**BEFORE the HEARING EXAMINER for the  
CITY of MERCER ISLAND**

**DECISION**

FILE NUMBERS: CAO15-001 & VAR18-002

TYPE OF CASE: Consolidated: 1) Critical Areas Reasonable Use Exception to construct a single-family residence and associated improvements within a regulated wetland and required wetland and stream buffers; and 2) Variance from the setback requirement from an access easement

Wetland and Wetland Buffer Impact Site Plan

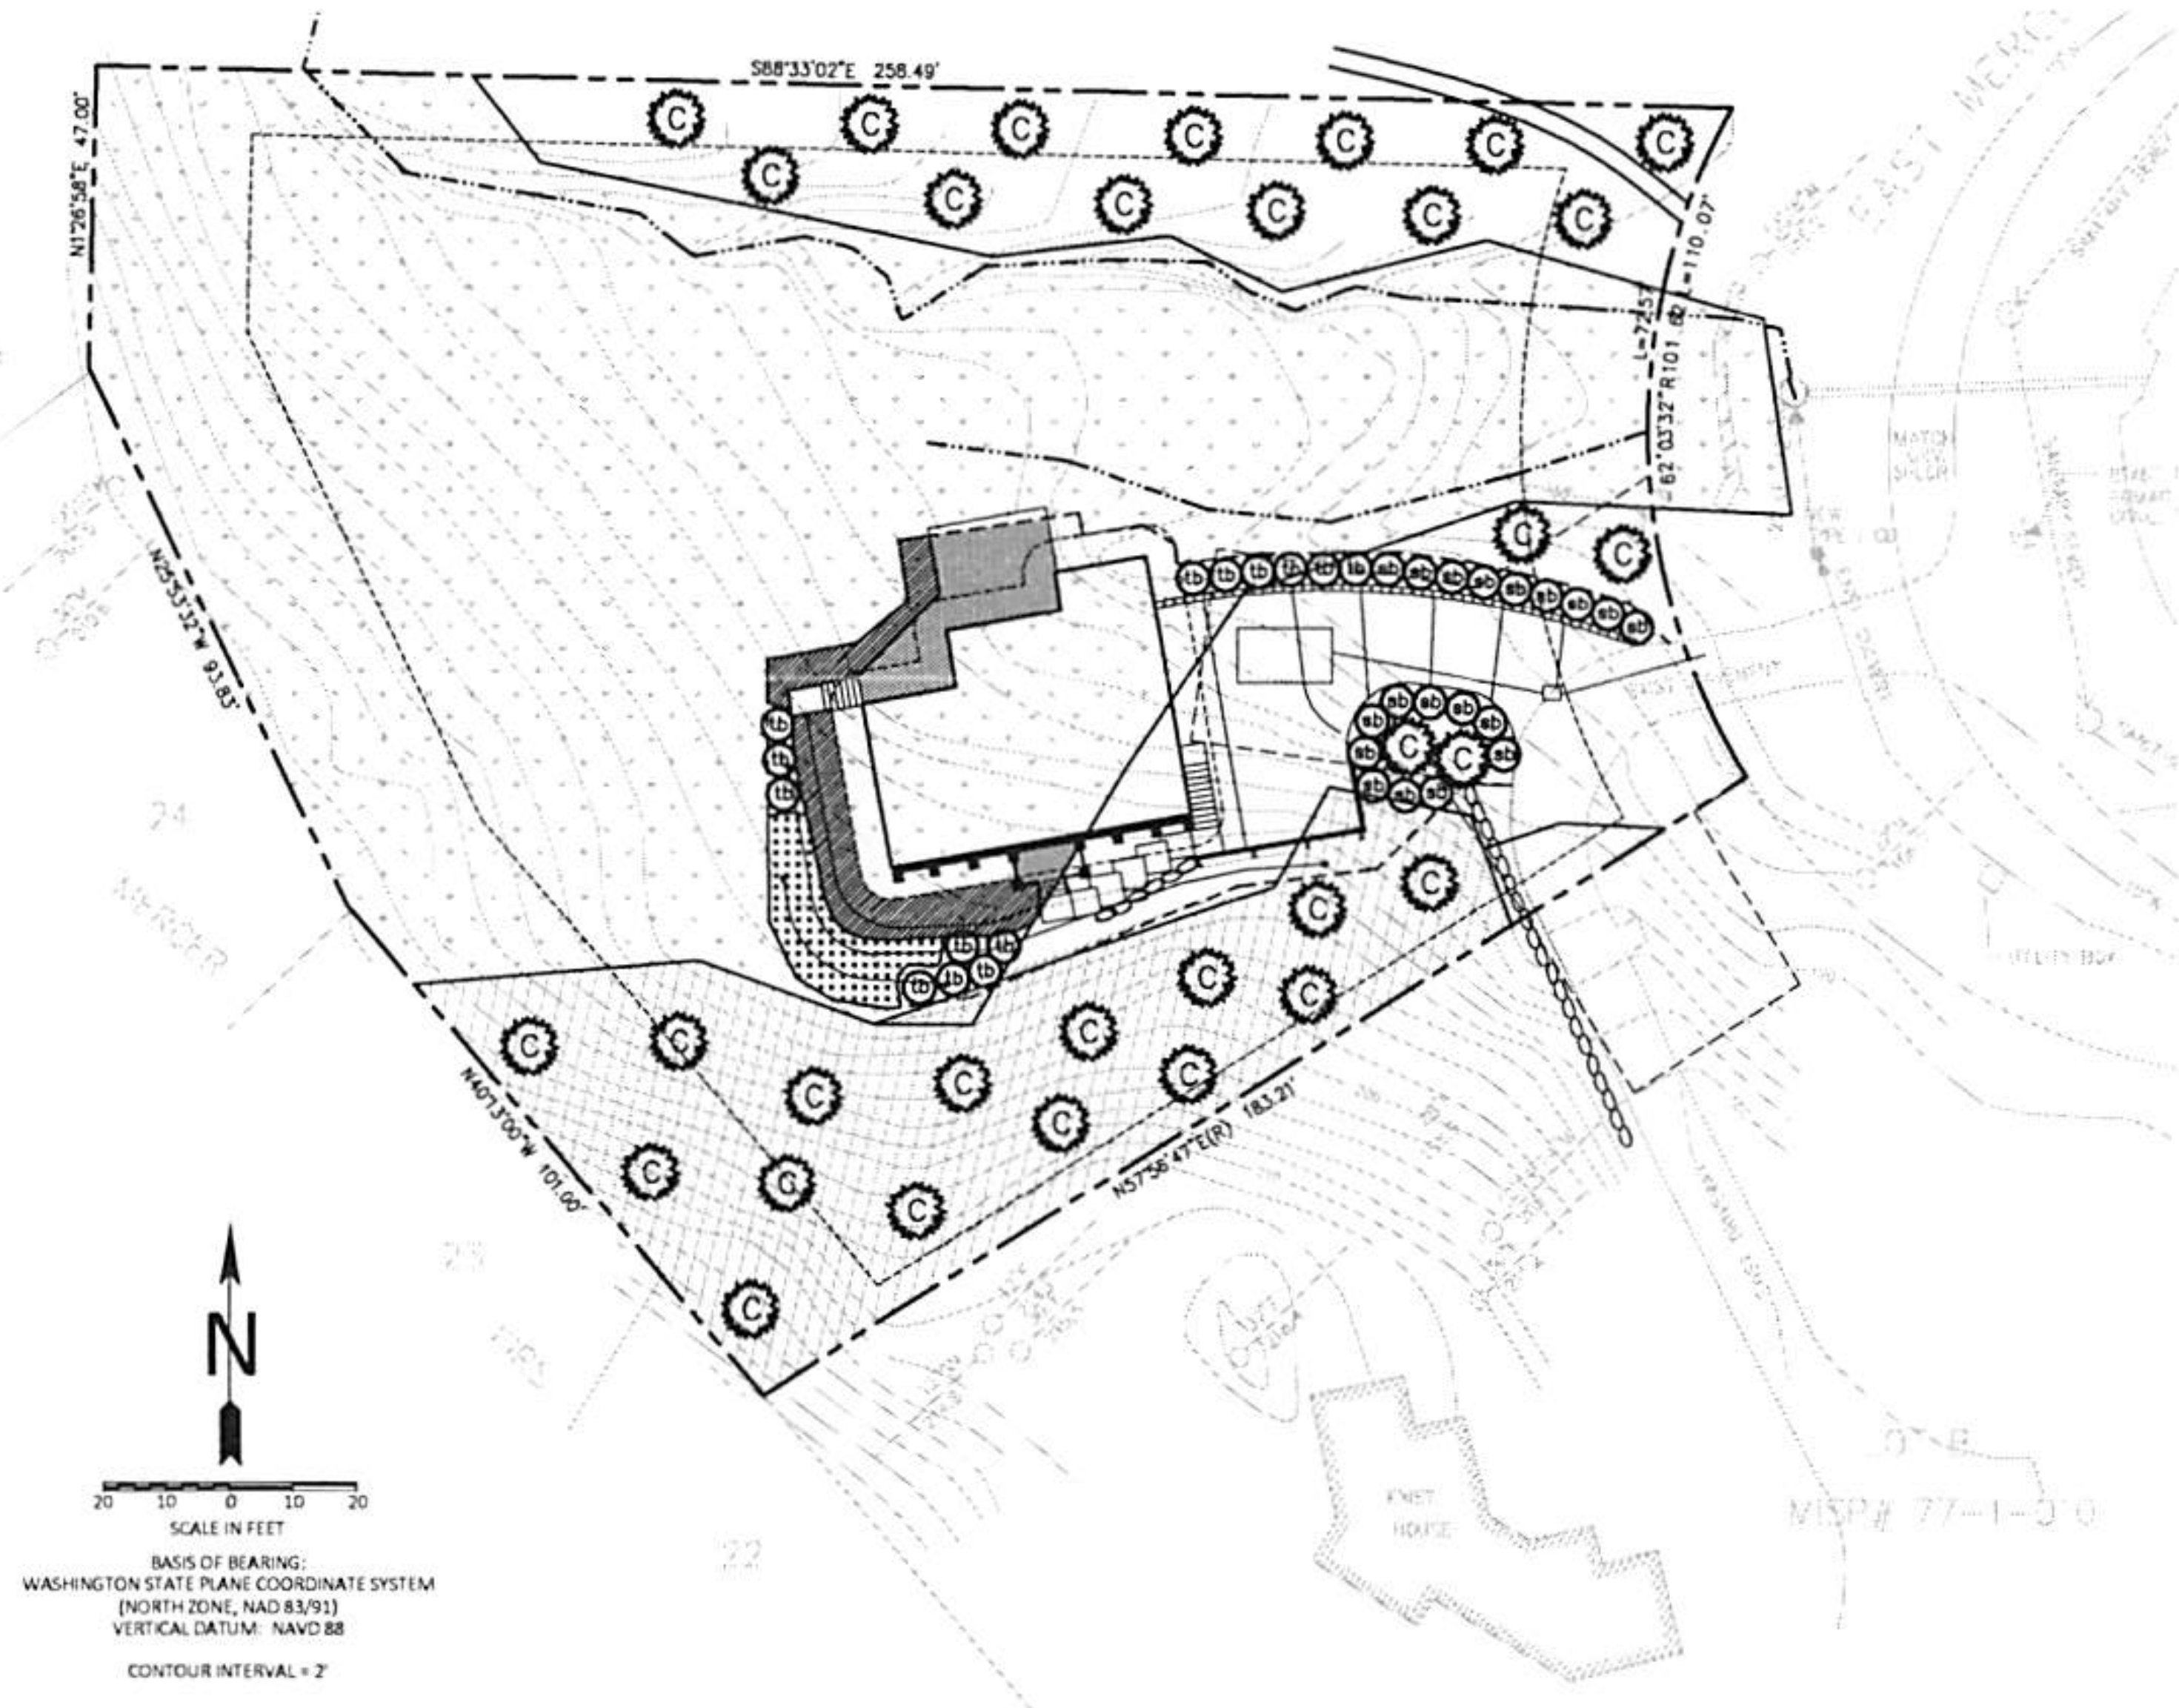
<sup>6</sup> The west property line segment call-out lengths on the currently proposed site plan (Exhibit 38) match the call-out segment lengths on the original short plat that created Parcel 9312 (Exhibit 39). However, the line segments as drafted on Exhibit 38 do not match the call-out lengths: The north segment which should be 47 feet is drawn as 57 feet; the middle segment which should be 94 feet is drawn as 65 feet; and the south segment which should be 101 feet is drawn as 119 feet. The total length is about the same, but the segment lengths and resulting angles are inaccurate. Thus, it appears that Parcel 9312’s shape is inaccurately presented on Exhibit 38.

Neither the off-site northern or western steep slopes are depicted on the proposed site plan, Exhibit 38.

<sup>8</sup> The inference from the contour lines on Exhibit 38 near the north property line that the parcel to the north exhibits gentle slopes is most likely quite mis-leading. Exhibit 23, Appendix A, PDF pp. 6 & 7 strongly suggests that the slope becomes significantly steeper immediately to the north.

15. Stream B is depicted in various locations and with various lengths on the maps and plans contained in the record. (Exhibits 12b, PDF pp. 3 & 20<sup>10</sup>; 12c, PDF p. 7; 38; 42d, PDF p. 5) On the latest project plan (Exhibit 38) Stream B defies geographical logic: It is depicted as flowing diagonally down the shallow side wall of a small, on-site draw. Streams simply do not do that in the real world.<sup>11</sup> Streams flow down the centerline of draws or ravines, not slaunchwise down their sides. If the topography on Exhibit 38 is accurate and if Stream B were properly mapped, it would originate at or flow beneath the northeast corner of the proposed residence, depending on its length. By drawing Stream B on the side of the slope, it misses the house by about seven feet. (Exhibit 38)
